From: Laura Mills
Sent: 20 May 2026 14:01
To: [REDACTED]
Subject: BE/35/26/HH 94 Stroud Green Drive, Bersted
Attachments: Householder Validation Requirements List 2024.pdf

Thank you for your recent planning application. I regret that I cannot accept the application until the following matters have been resolved:

24 STROUP GREEN DRIVE
BE/35/26/HH
FRONT ELEVATION (WEST)

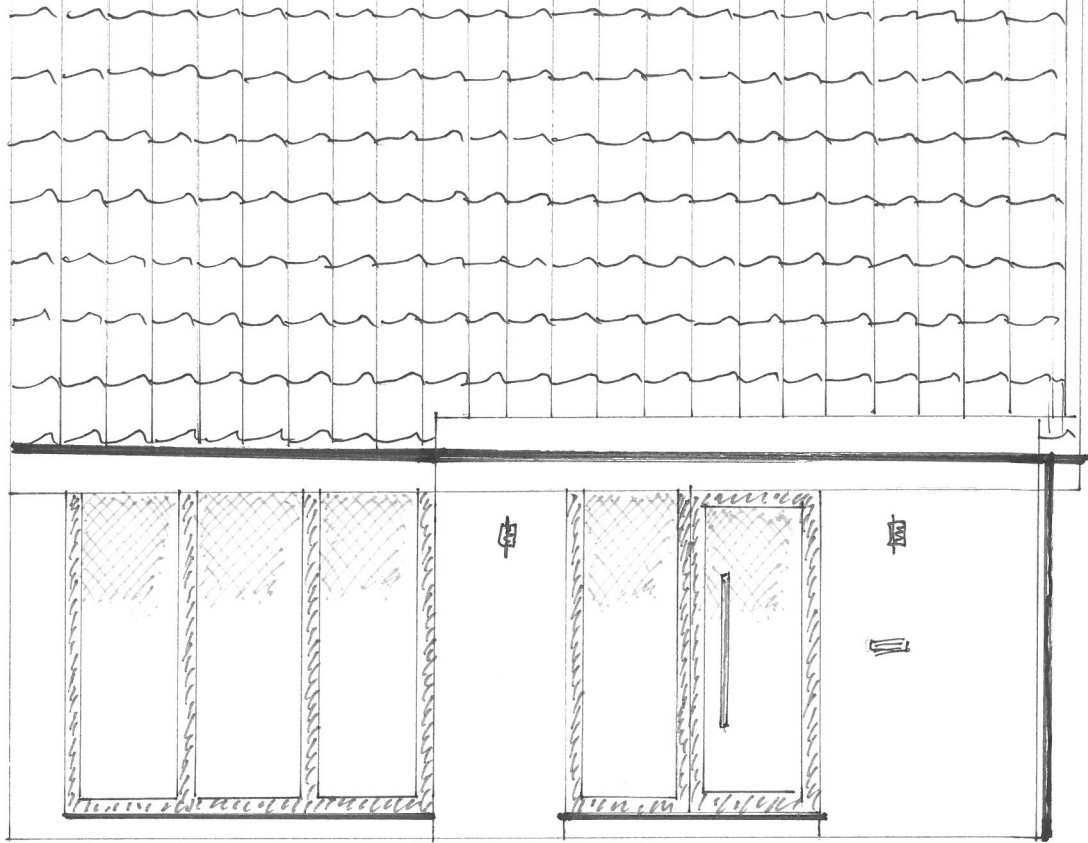
1. Location plan – please amend the red edge so that it goes around the entire site. (Currently the red edge does not go through the house)
2. Block plan – please show the location of the proposed porch on the plan and hatch or highlight this.
3. Elevations and floor plans – these need to be scalable plans in a pdf format to a scale of either 1:50 or 1:100. We cannot accept the plans in the format you have provided them.
4. Biodiversity enhancement statement – this statement should state how you have sought to improve the existing onsite natural environment. This can be as straightforward as providing a statement to say you are going to add a bat box or bird box or whatever you wish that would improve biodiversity.
